Grendon Parish Council – Flooding, Land-Use, Traffic & Cumulative Impact Report

For submission to the Examining Authority (Green Hill Solar Farm, EN010170)
November 2025

Title:
Figure 13.10: Public Rights of Way within the
Study Area (North Area)

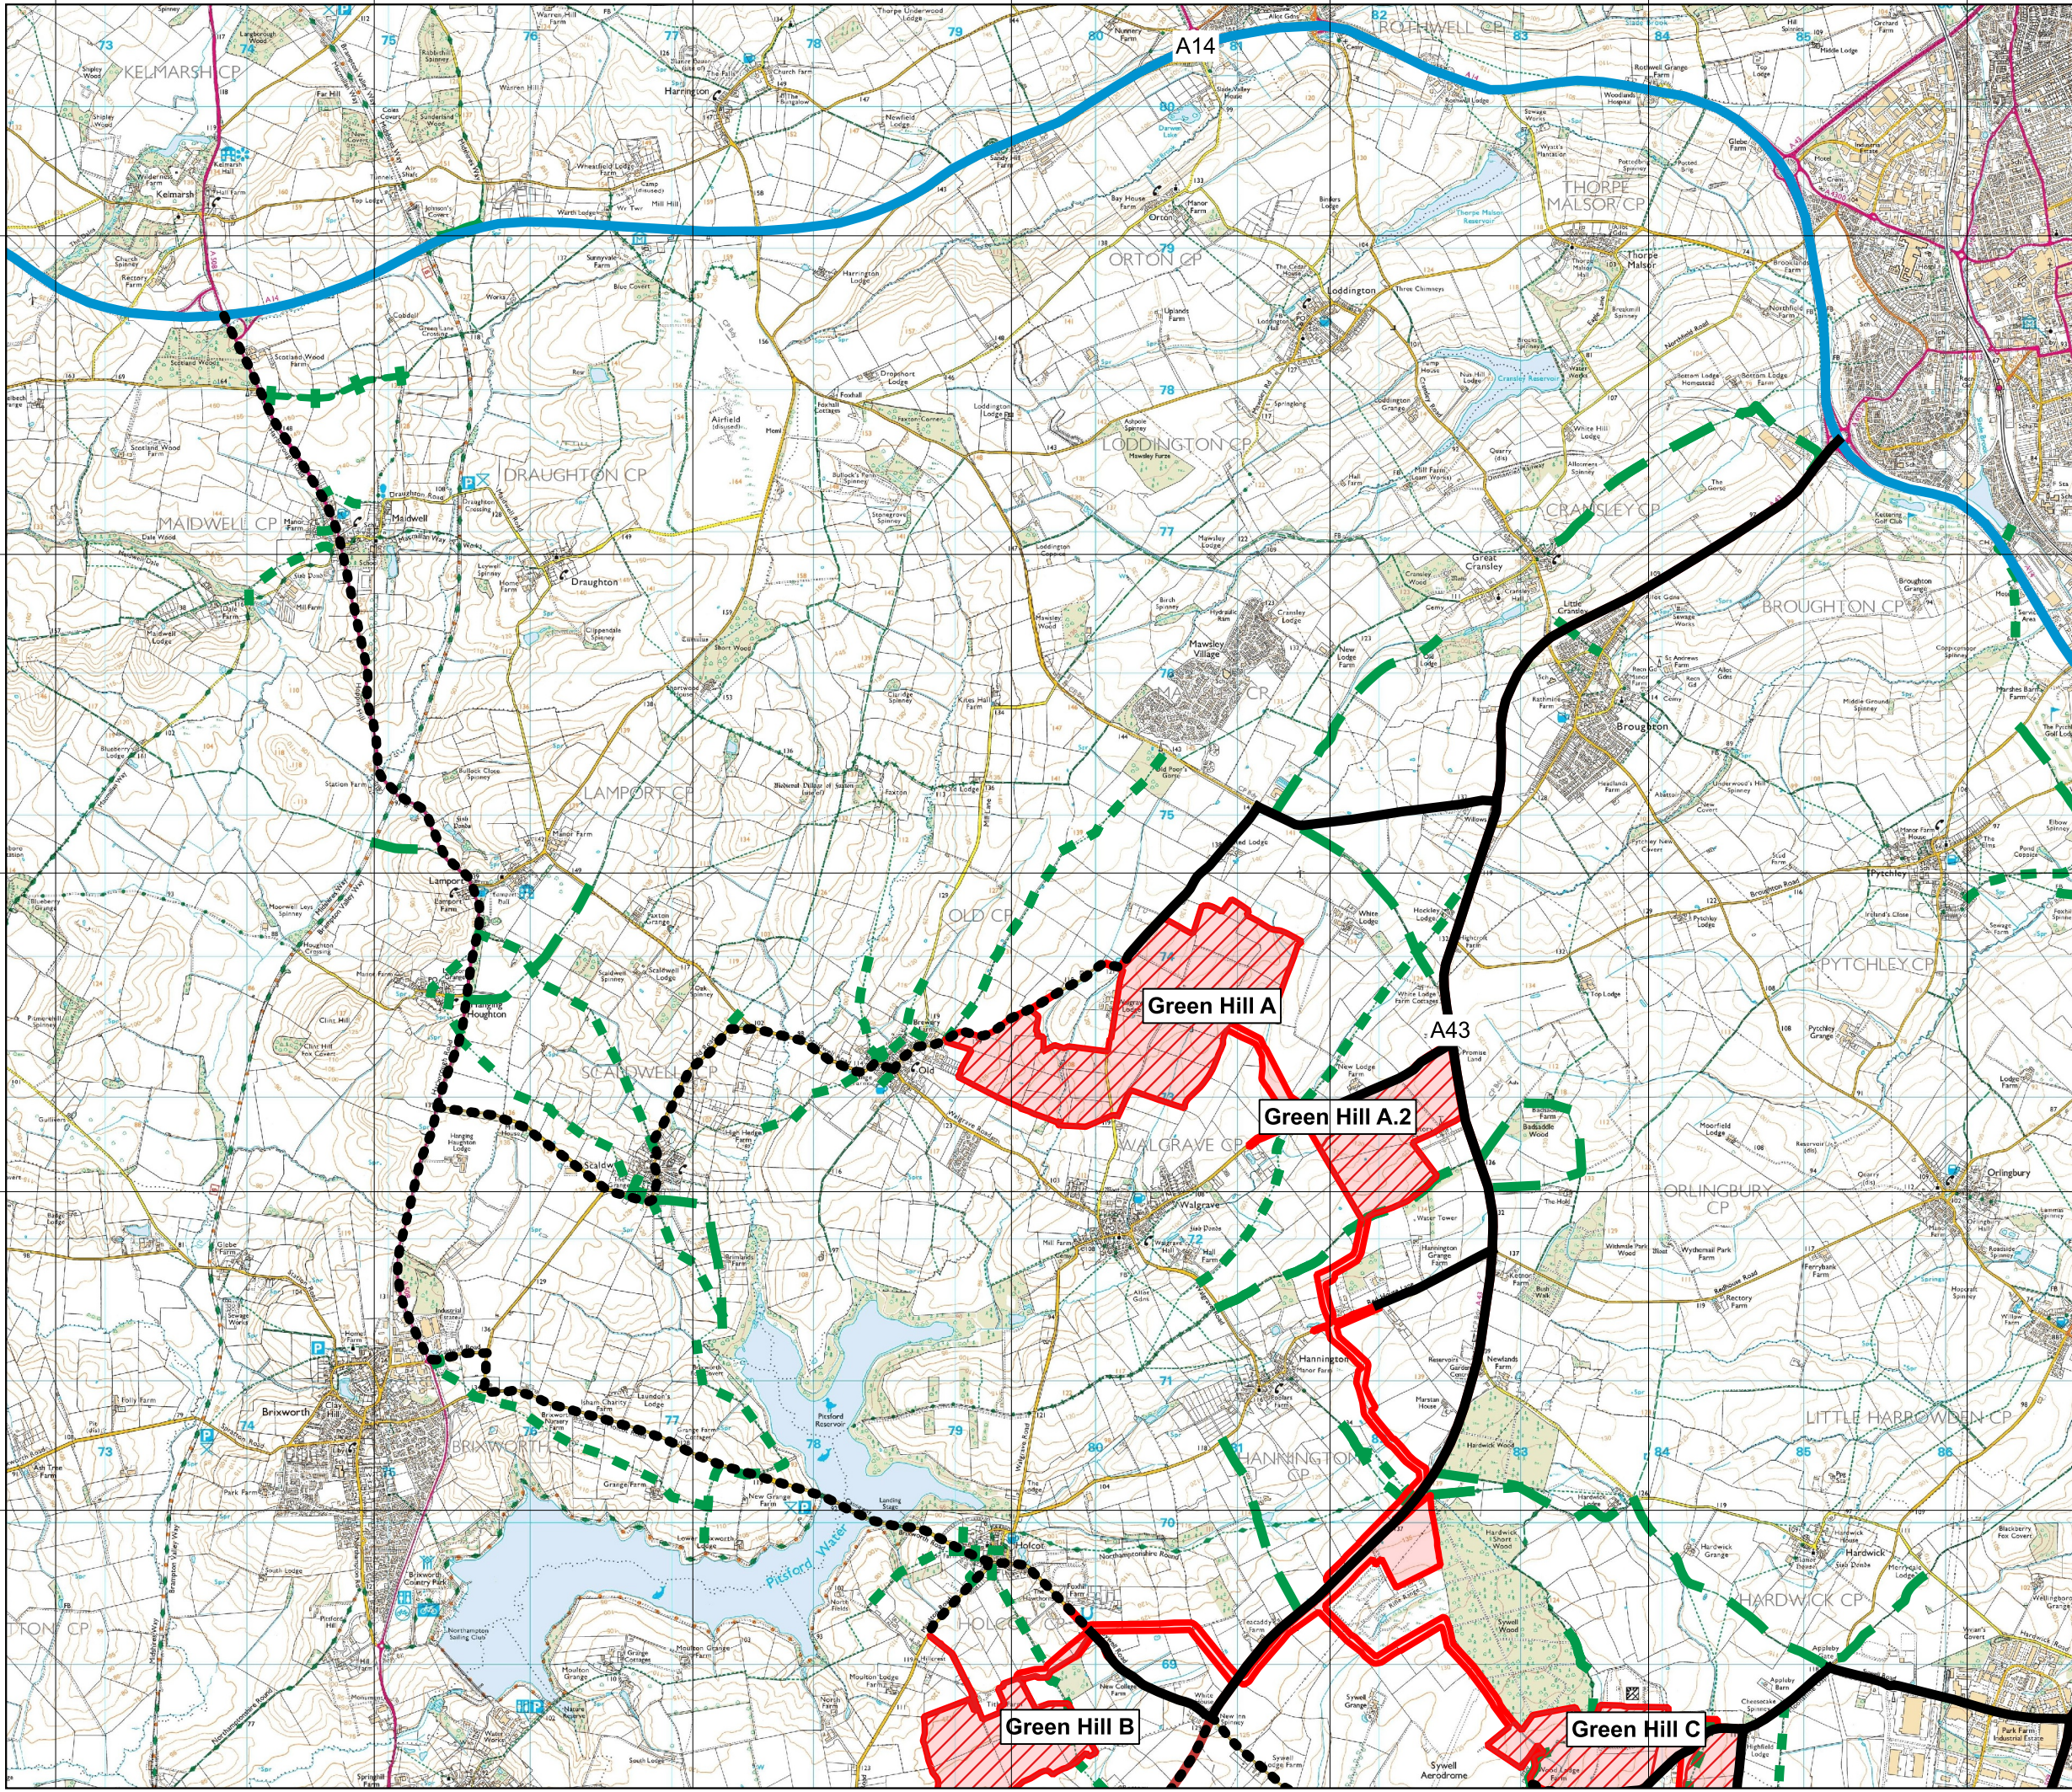
PROW and bridleway concerns:

The development proposes changes to public rights of way and to the route of the Weandal Walk between the villages and through the site.

- Solar panel corridors are planned to run close to or across the footpath, potentially replacing open access with fencing or 4.5 m high hedging, which would reduce visibility, degrade amenity and discourage walking with prams/push-chairs or small children. Now, they have stated, they will temporarily close some and reroute others.

- Pedestrian connectivity is a key community asset; any rerouting or enclosure must not reduce safety, accessibility or enjoyment of the route. The Council requests clarity on how the applicant will maintain safe, direct, well-signed footpaths accessible to all.

- The scheme will be disruptive and not enhance the openness of the long established local footpaths linking Easton Maudit, Yardley Hastings and Cogenhoe. Many of these are part of the annually held international Waendal Walk which attracts around 3,000 visitors per year supporting local businesses. Industrial fencing and closures would break the route and damage local commerce and tourism.

- The proposed closure of our walking route to Castle Ashby during the 2 year construction – the most used link to a village shop and local amenities – means residents from both villages who currently walk there and back will be forced to travel by car instead. (And the road routes will both be subject to traffic management measures). There is no alternative shop within comfortable walking distance. The closure threatens to increase car usage significantly and remove a vital non-motorised access for everyone.

8. **Demands a Public Rights of Way and Access Statement** ensuring all paths, including the Waendel Walk and Castle Ashby route, remain safe and open, with well-signed alternatives if closures are unavoidable.
